EL PASO COUNTY STORMWATER MANAGEMENT PLAN CHECKLIST

EPC Project Number: CDR2312

TRAILS AT ASPEN RIDGE - STOCKPILE					
CONSTRUCTION DRAWINGS GRADING AND EROSION CONTROL PLANS					
GRADING AND EROSION CONTROL PLAN					
DESIGNED BY:	NMS	SCALE	DATE ISSUED:	MAY 2023	DRAWING No.
DRAWN BY:	TRS	HORIZ	N/A		
CHECKED BY:	NMS	VERT.	N/A	SHEET	3 OF 8
					GEC01

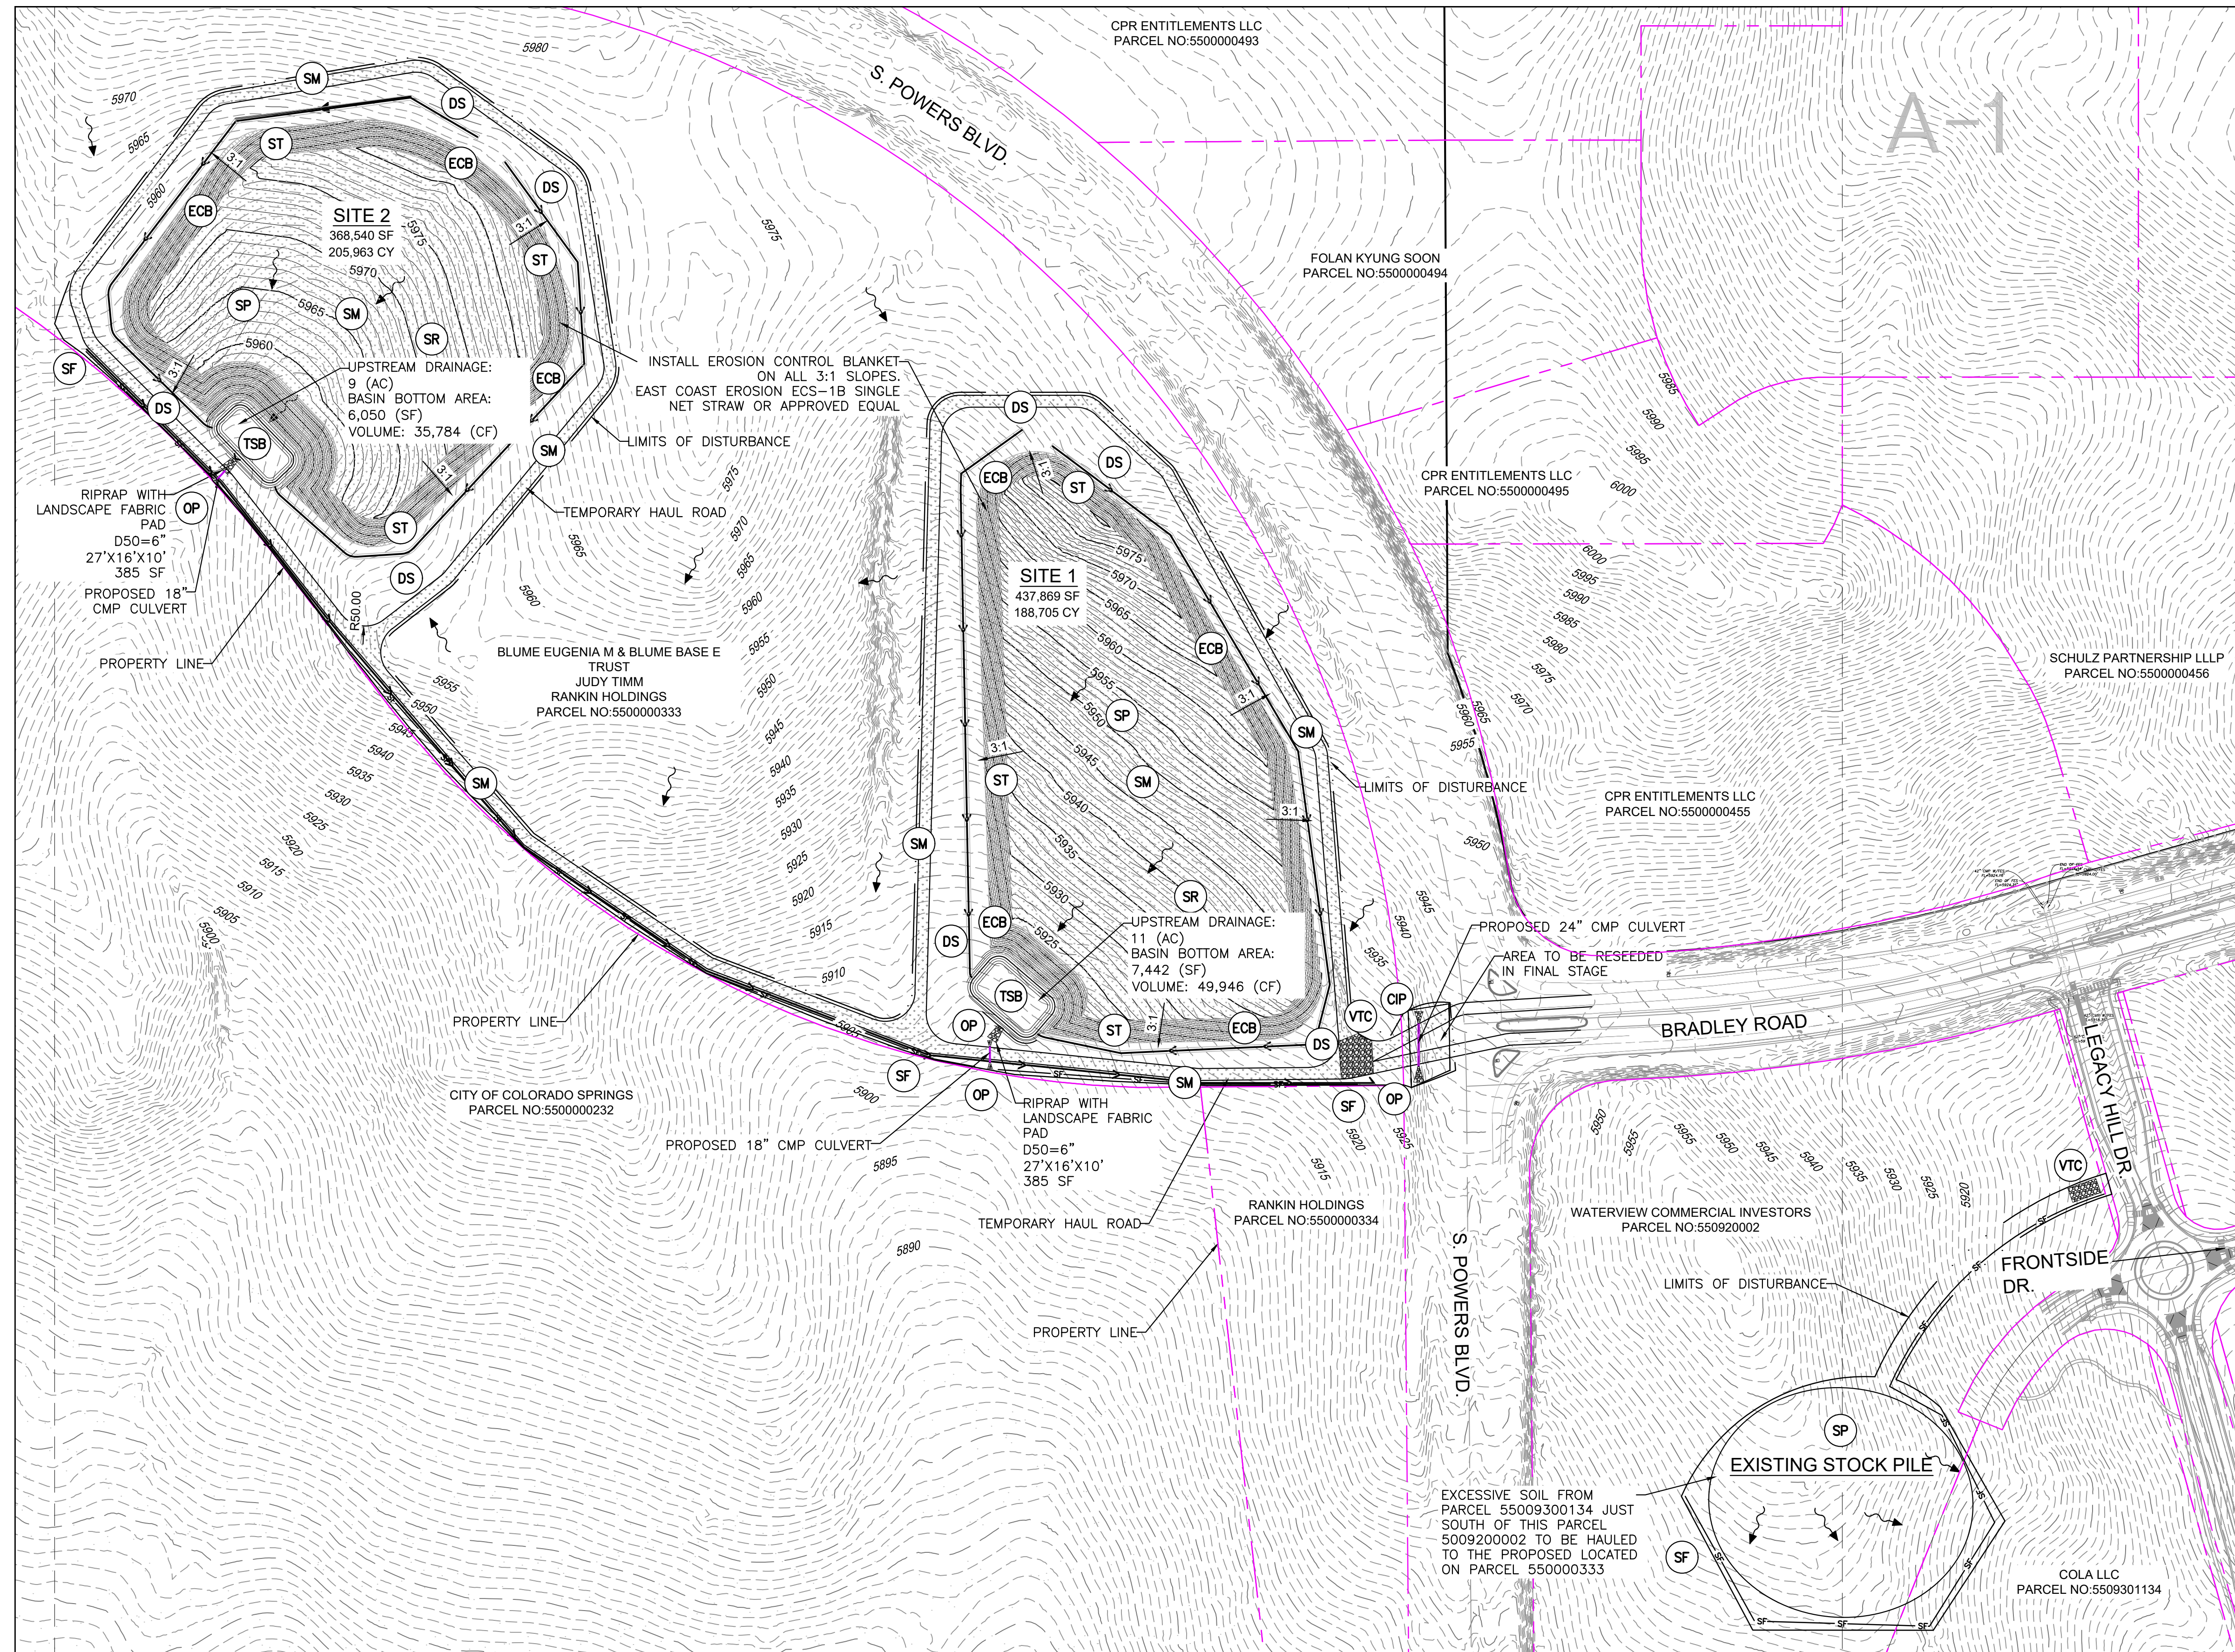
Applicant	EPC
17	SWMP Map to include:		
17a	construction site boundaries		Y
17b	flow arrows to depict stormwater flow directions		N
17c	all areas of disturbance		Y
17d	areas of cut and fill		Y
17e	areas used for storage of building materials, soils (stockpiles) or wastes		Y
17f	location of any dedicated asphalt / concrete batch plants		Y
17g	location of all structural control measures		Y
17h	location of all non-structural control measures		Y
17i	springs, streams, wetlands and other surface waters, including areas that require maintenance of pre-existing vegetation within 50 feet of a receiving water		Y
18	Narrative description of all structural control measures to be used. Modifications to EPC standard control measures must meet or exceed County-approved details		Y
19	Description of all non-structural control measures to be used including seeding, mulching, protection of existing vegetation, site watering, sod placement, etc.		Y
